Rezoning Transportation Analysis

Petition Number: 2020-025

Revision Log:	Date	Description
	02-15-2020	First Review

SHEET NUMBER  
**RZ-1**

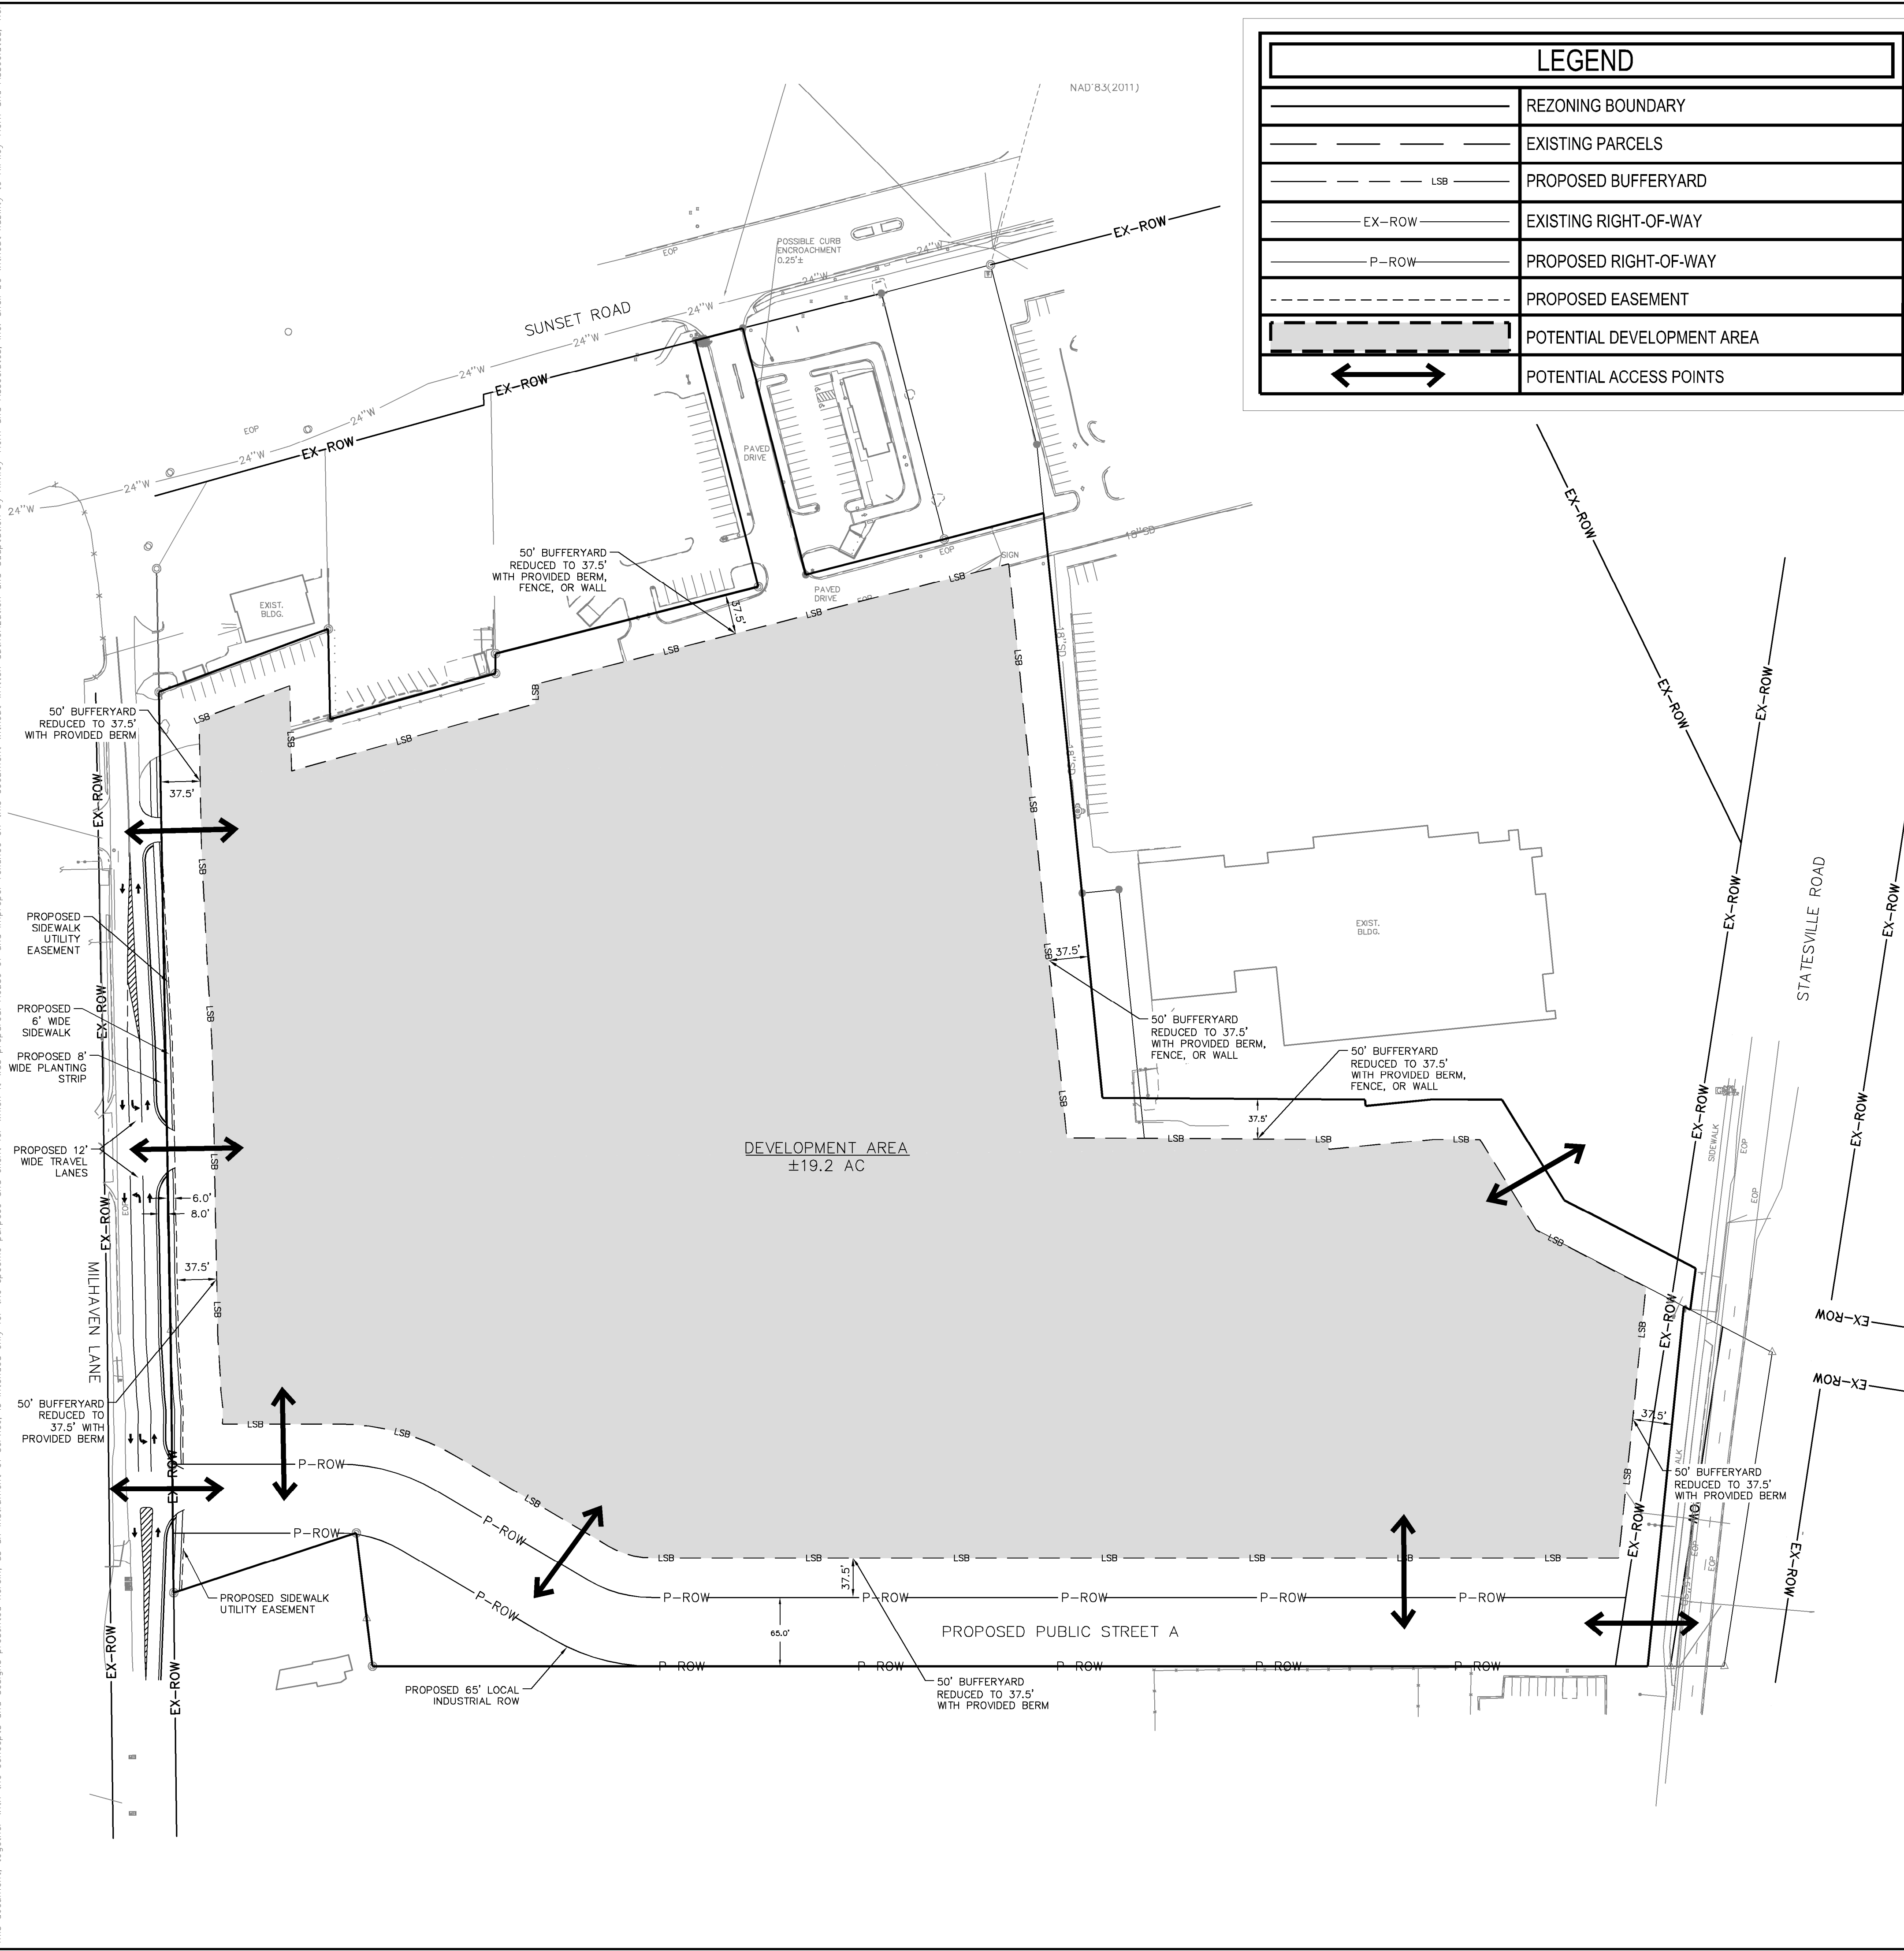
The site is located along a major thoroughfare. The petitioner should revise the site plan to meet current requirements.

- The petitioner should revise the site plan and conditional note(s) to construct a North/South road to public standards per subdivision ordinance.

- The petitioner should revise the site plan and conditional note(s) to add a left turn on Statesville Road to site aligned across from Keith Drive.

- The petitioner should revise the site plan and conditional note to
- The petitioner should revise the site plan to add a note specifying dedication and fee simple conveyance of all rights of way to the City before the site's first building certificate of occupancy is issued. CDOT requests right of way set at 2' behind back of sidewalk where feasible.
- The petitioner should revise the site plan to add a note specifying all transportation improvements will be approved and constructed before the site's first building certificate of occupancy is issued. The

petitioner may phase transportation improvements if said improvements and phasing are explicitly described in site plan notes.
